## POST EPC MEMORANDUM

TO: CABQ Development Facilitation Team (DFT)  
FROM: William Steele, Senior Planner  
DATE: 05/08/25  
RE: PR-2024-011052, SI-2024-01468 – Site Plan – EPC

3/24/2025
Project NO: 2024-120
COPYRIGHT MITCHELL ASSOCIATES INC. ALL RIGHTS RESERVED.
Drawing No. 1 of 1
LS-101

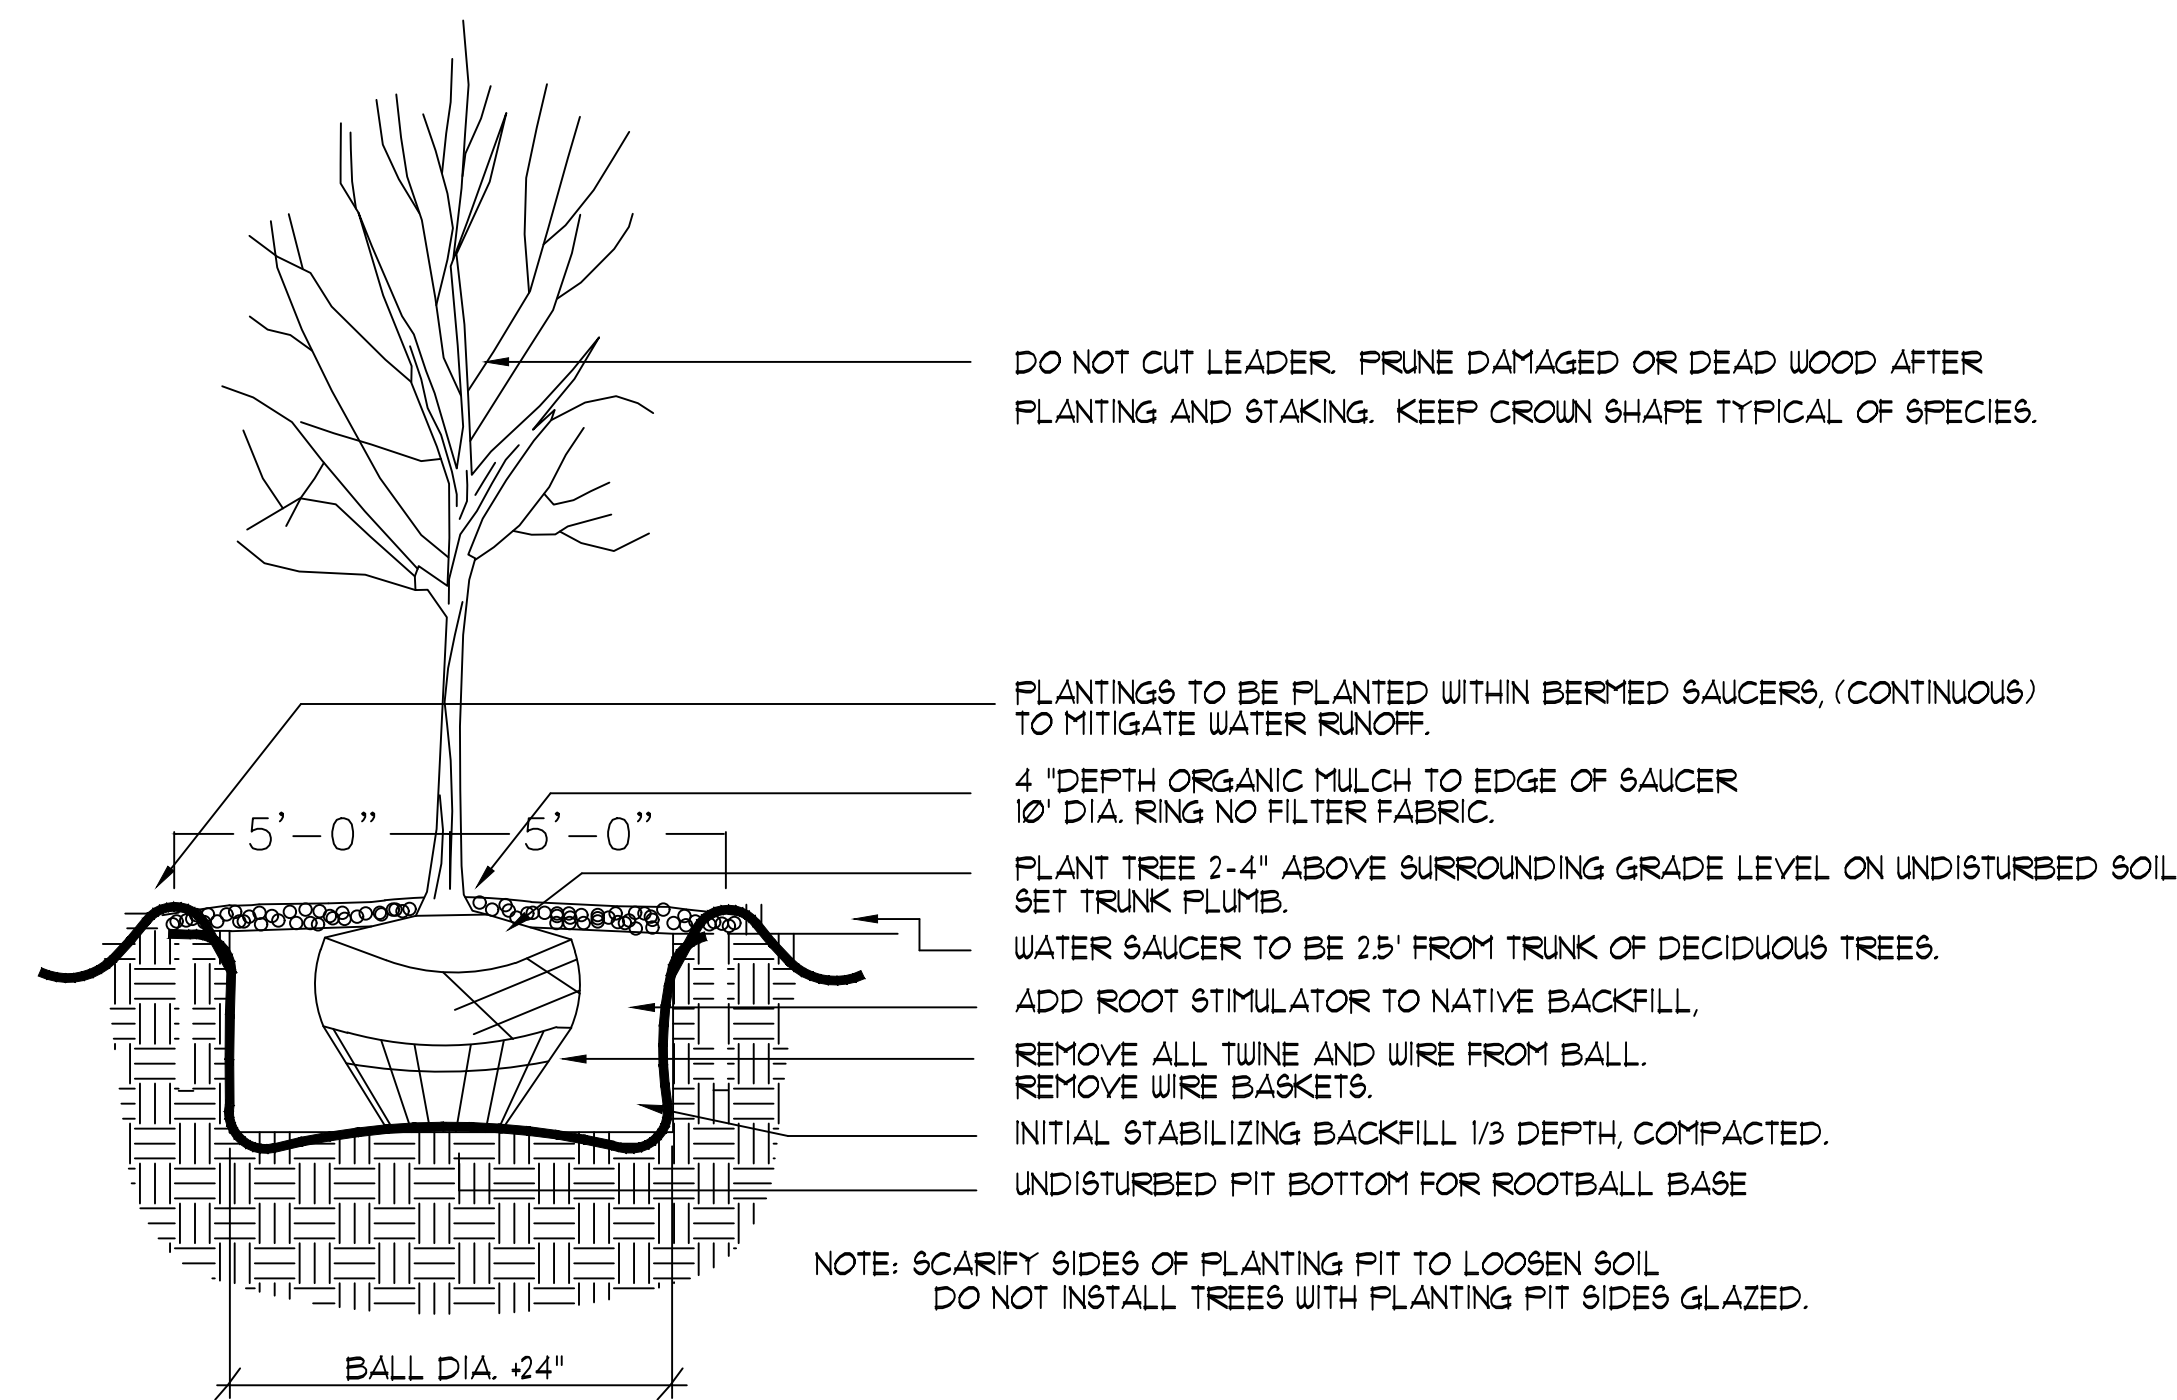
- Landscape Plan shall be stamped and signed by a licensed Landscape Architect.
- Revise the Landscape Plan to clearly show what is existing and what is to remain.
- Per Street Tree Ordinance 6-6-2-4 REQUIRED STREET TREES (1) All applicants for building permits for construction of a new building or building addition of 200 square feet or more shall submit a street tree plan for those parts of the lot abutting a major street, a major local street, or another street where street trees are required.
- Show street trees 25 feet on center along Westside Boulevard.
- Revise the Landscape Plan to select a tree species other than ash trees, which are overplanted and struggling in current climate conditions.
- Work with Urban Forestry to revise the Landscape Plan to identify the shrubs to be replaced and maintained.

*A LANDSCAPE PLAN (EXISTING) sheet (LS-101) was added to the drawing set to clearly identify what landscaping is existing on the site.*

EAST ELEVATION
1/A2.1

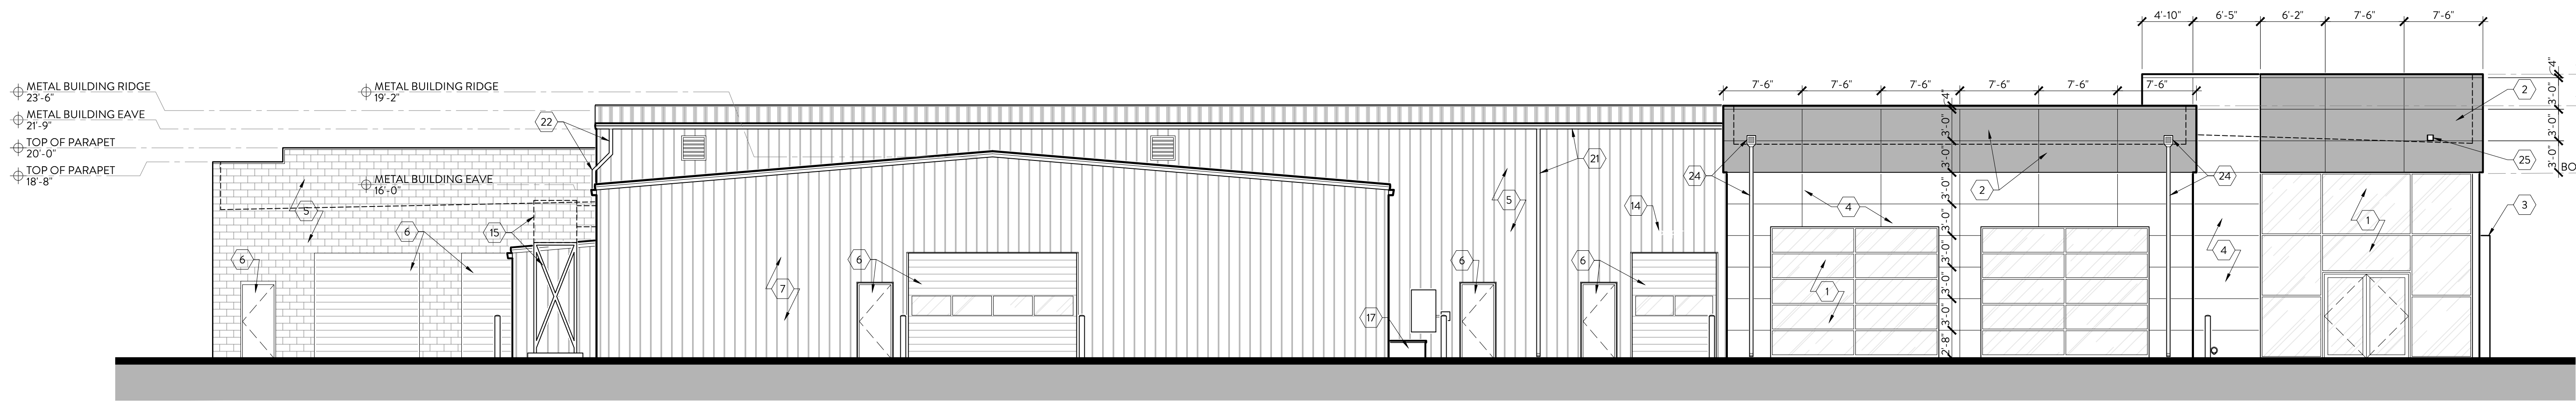
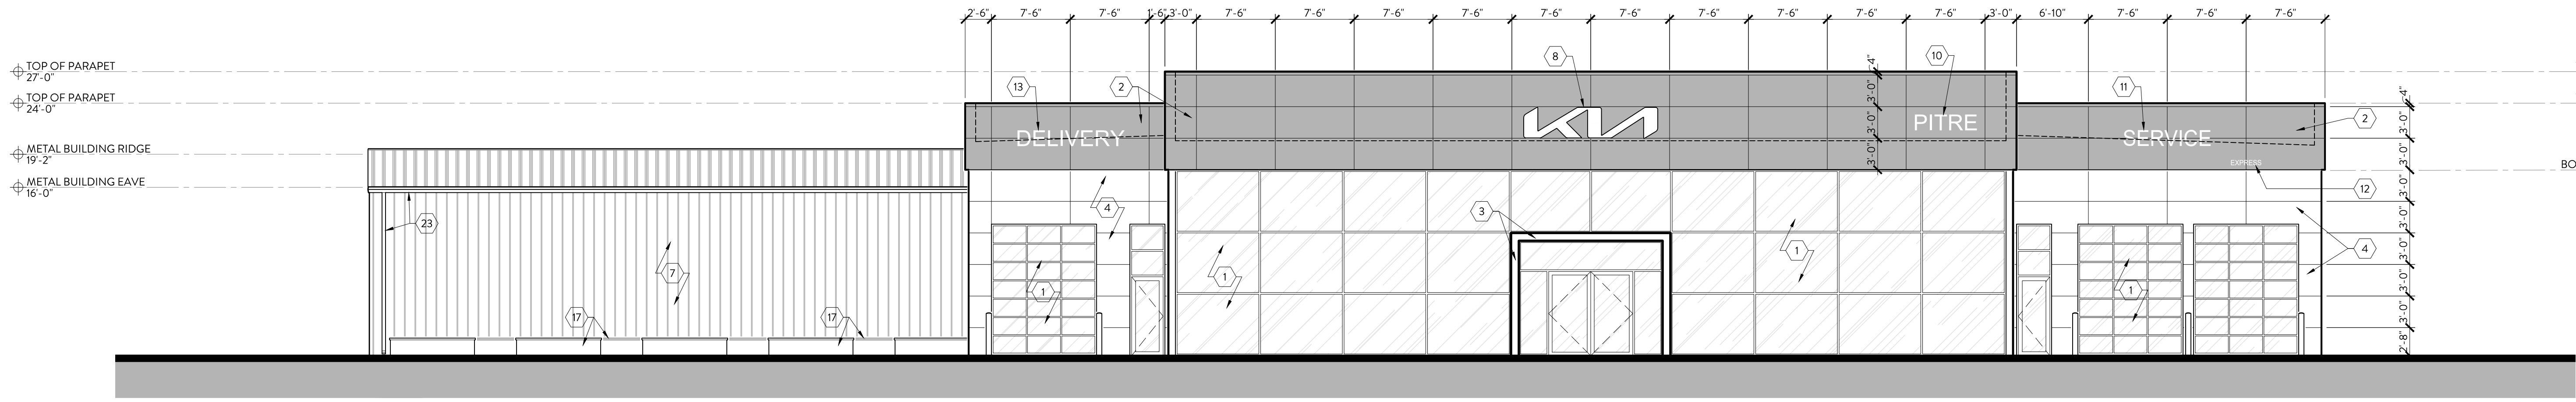
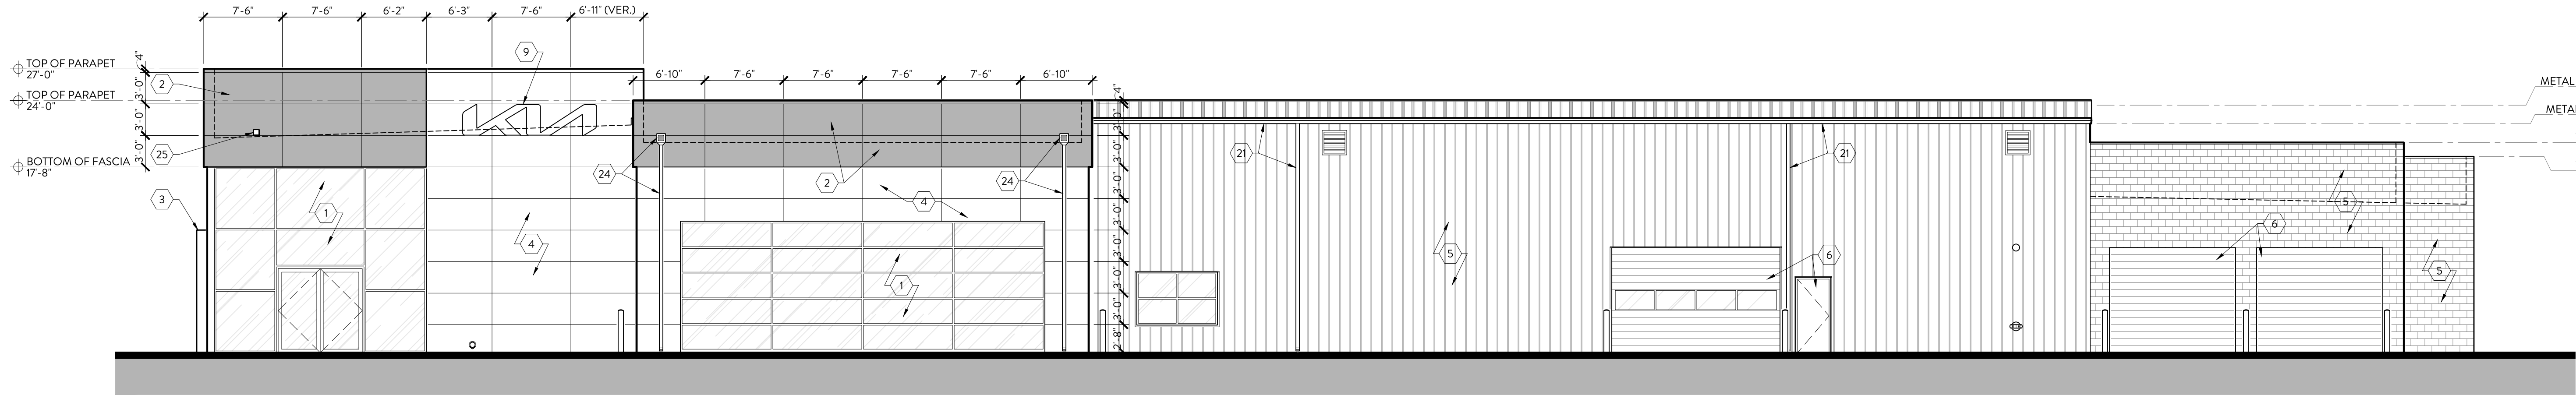
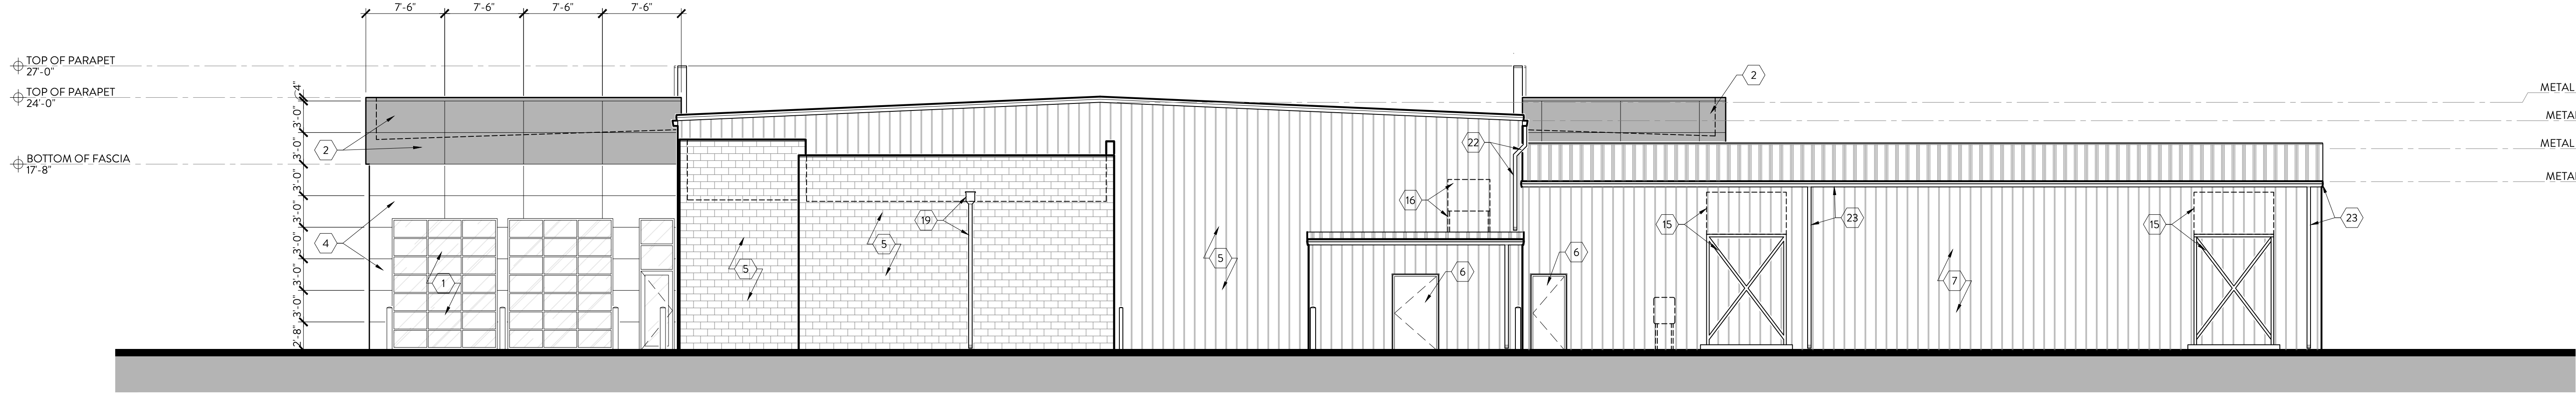
- A. The missing “Parts” sign on the East (Side) Elevation for Keyed Note #14 shall be added to this sheet.

*The “Parts” sign is not shown on the East Elevation. Note #14 is pointing to the wall above a small garage door. Please show the “Parts” sign on the elevation sheet.*

- B. The North (Front) Elevation of the proposed addition with the 57’-0” façade shall incorporate 1 required feature every 40’-0” to adhere to the required total of 2 features along 30 percent of the length of the façade pursuant to §14-16-5-11(E)(2)(a)-(g).

*A planter has been incorporated along the 57’ façade (proposed addition) of the North Elevation to meet the requirement of 1 feature every 40’-0”. The new planter is also shown on the Site Plan sheet.*

PARTIAL NORTH ELEVATION @ SERVICE ADDITION
5/A2.1

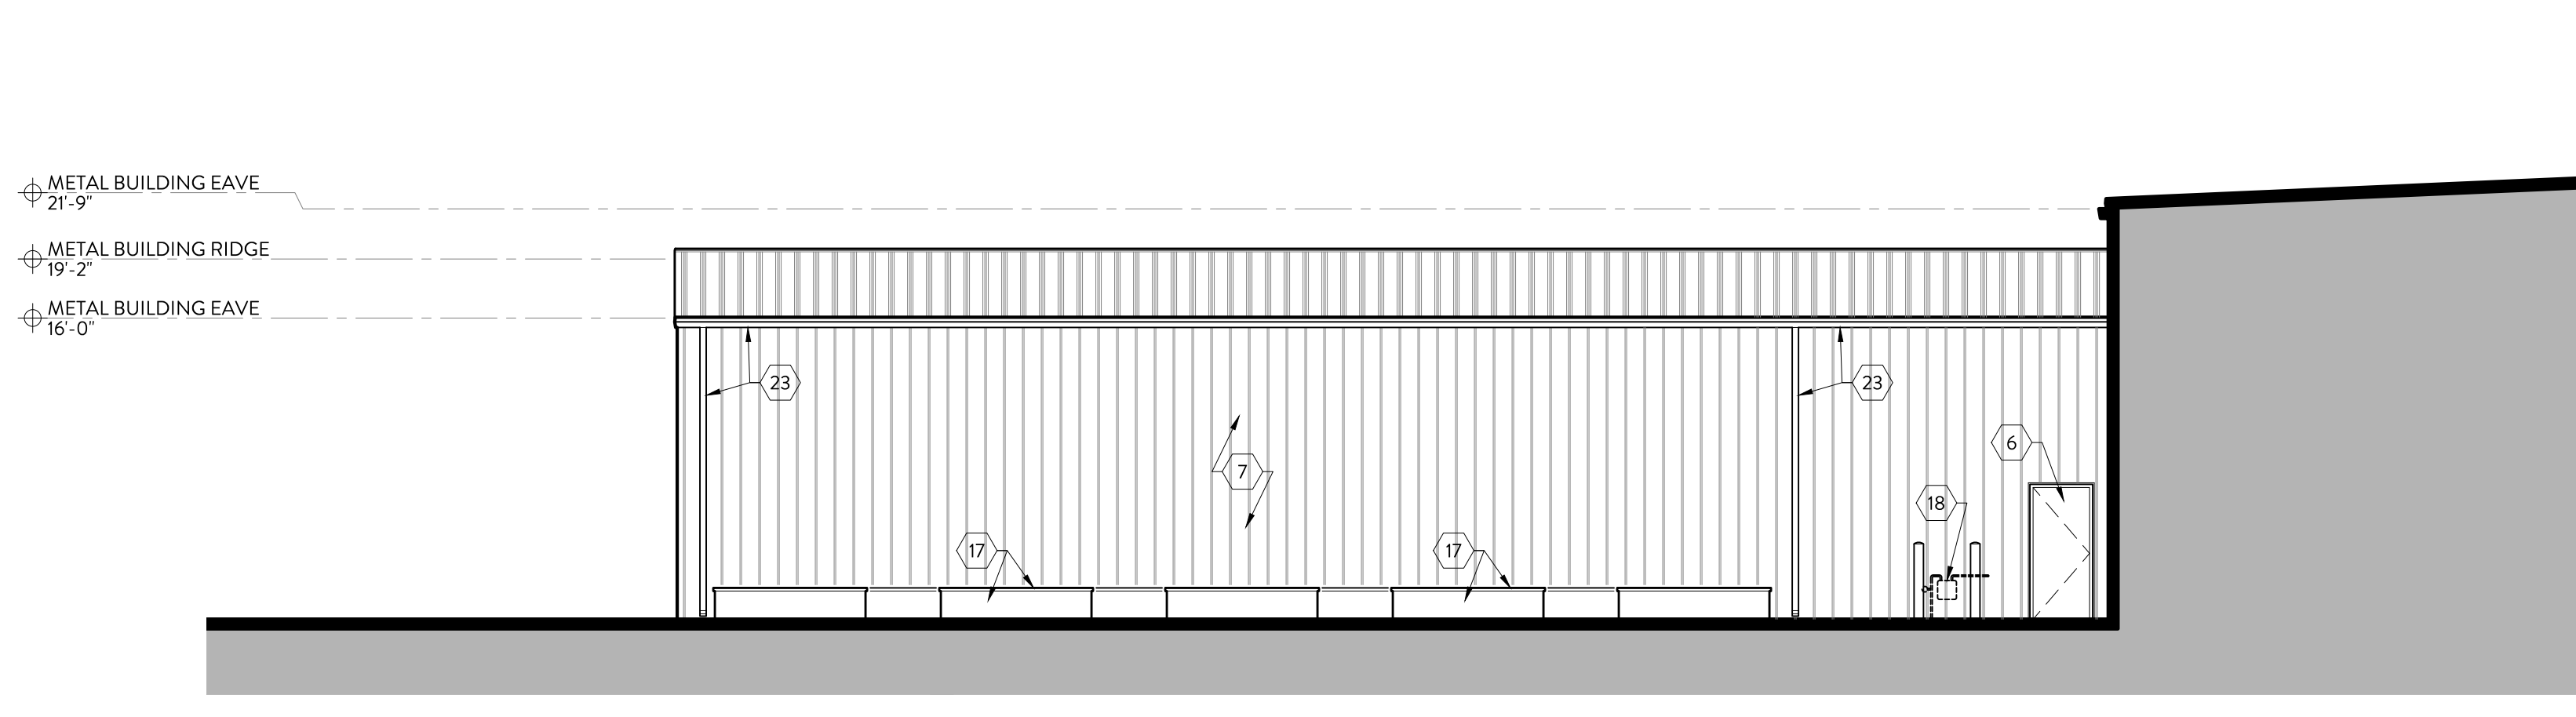
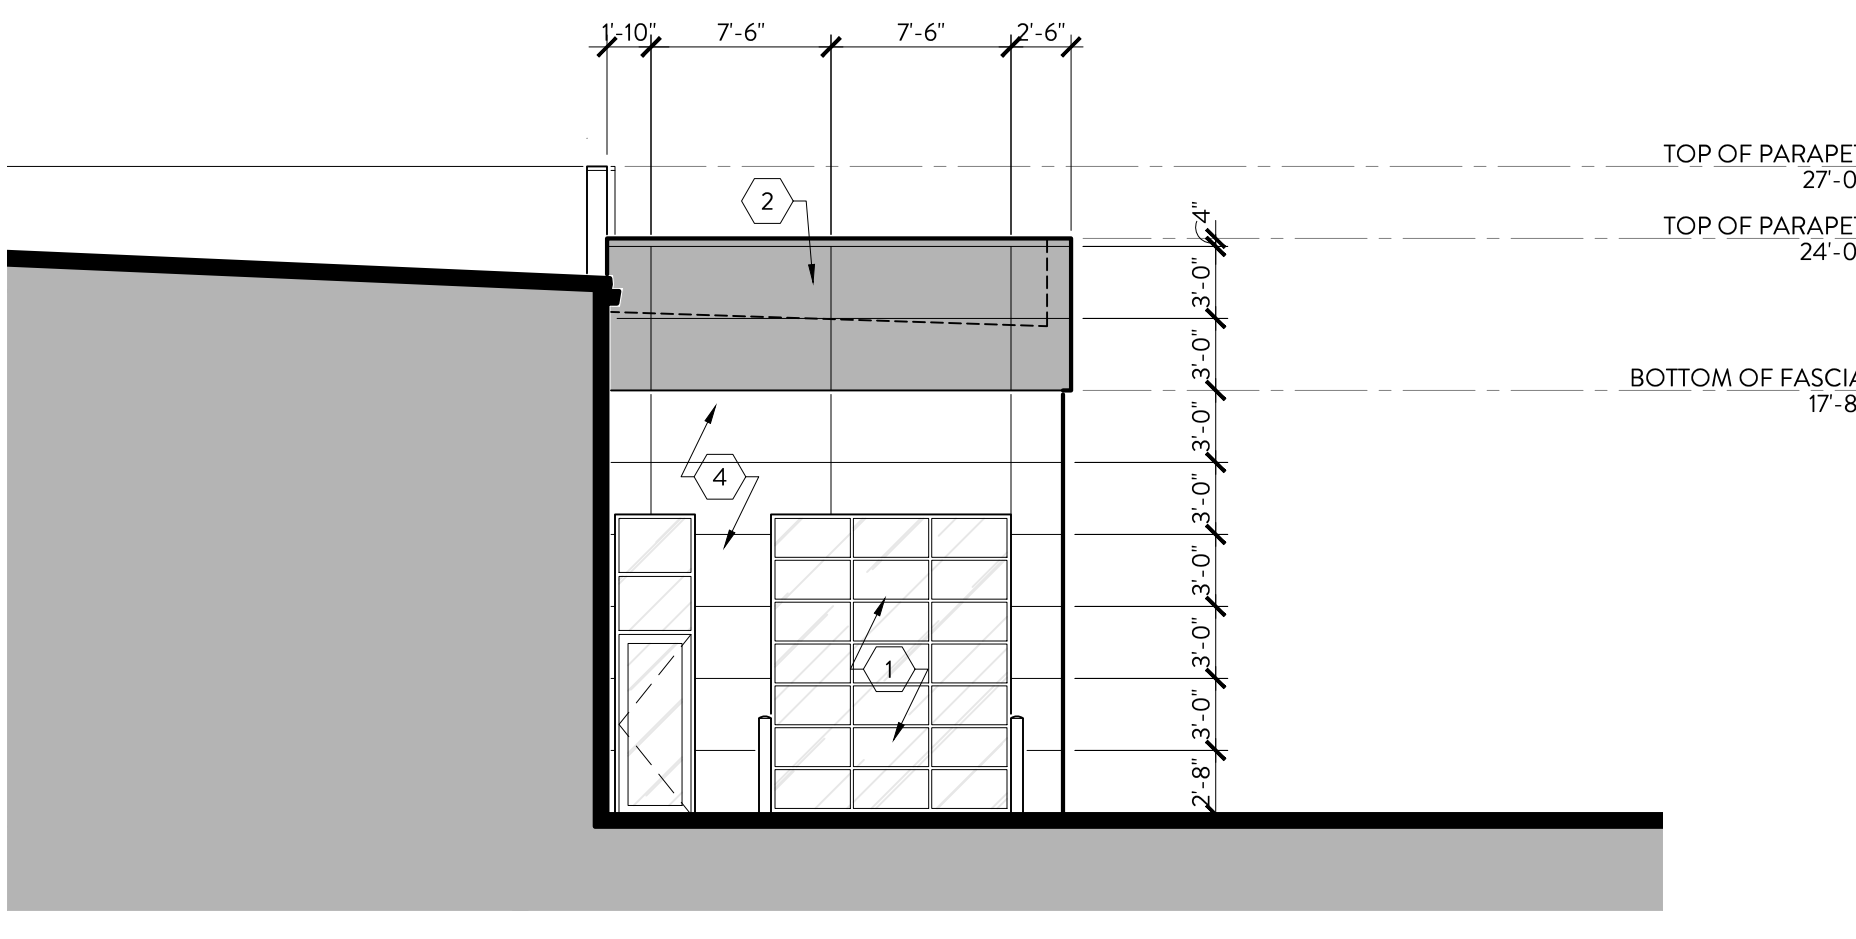
4. Two new elevations have been added to the EXTERIOR ELEVATIONS sheet (A2.1): Partial North Elevation @ Service Addition and Partial South Elevation @ Vehicle Delivery. These new elevations provide clarity to the drawings. It is acceptable to leave the elevations on the drawing although not approved by EPC. The new elevations will not be reviewed by the EPC Staff Planner because they are not part of the EPC's Conditions of Approval in the November 21, 2024 NOD.
